City of Albuquerque

April 7, 1986

RE: REVISED DRAINAGE PLAN FOR EARL SCHEIB PAINT SHOP
(K-10/D17) ENGINEER'S STAMP WITH REVISION DATE APRIL 1, 1986

DRAINAGE AND GRADING PLAN FOR EARL SCHEIB PAINT SHOP

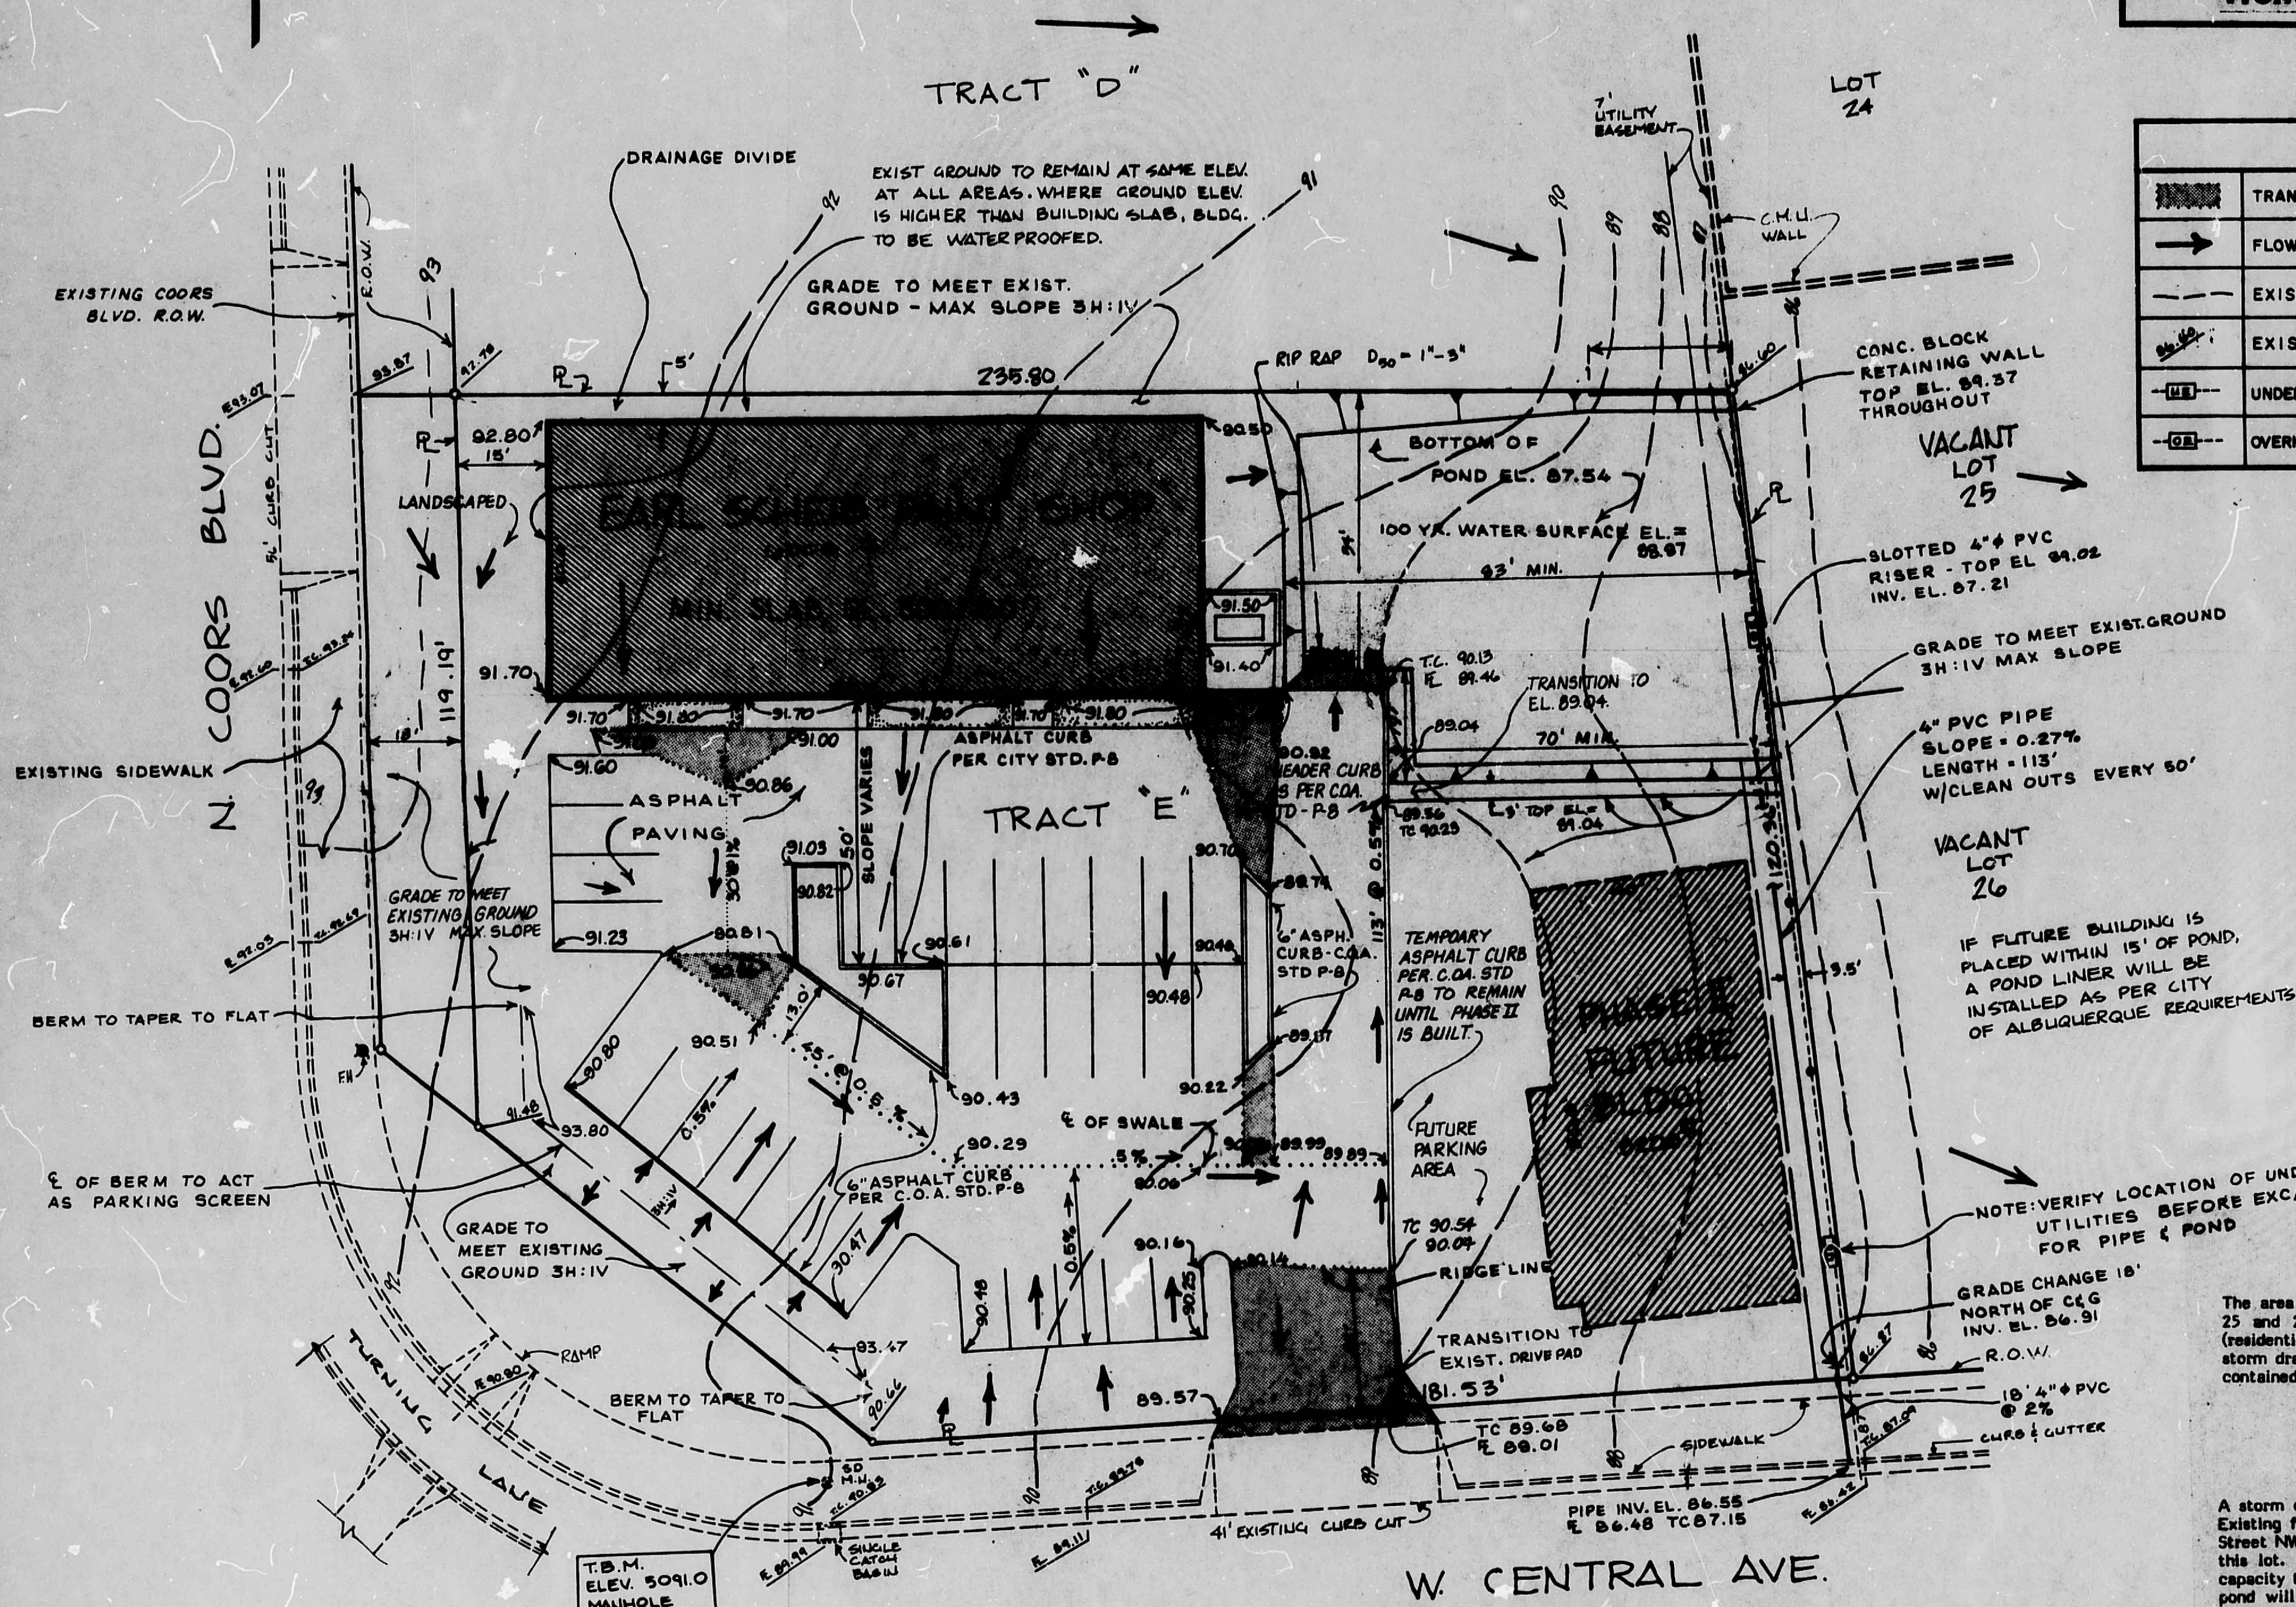
Based on the information provided on your April 1, 1986 resubmittal, revisions as indicated are acceptable.

REMARKS Roger, This plan was approved 12 December 1985 for Building Permit. However the Site Plan was changed after the approval date + we have revised the drainage + grading plan. The pond size was not changed. Since the impervious area was reduced in the revised Site Plan (parking lot size was reduced and landscape area was increased) we did not redo the calculations or change the pond size. This will COPY TO be more than adequate since the revised runoff rate and volume will decrease
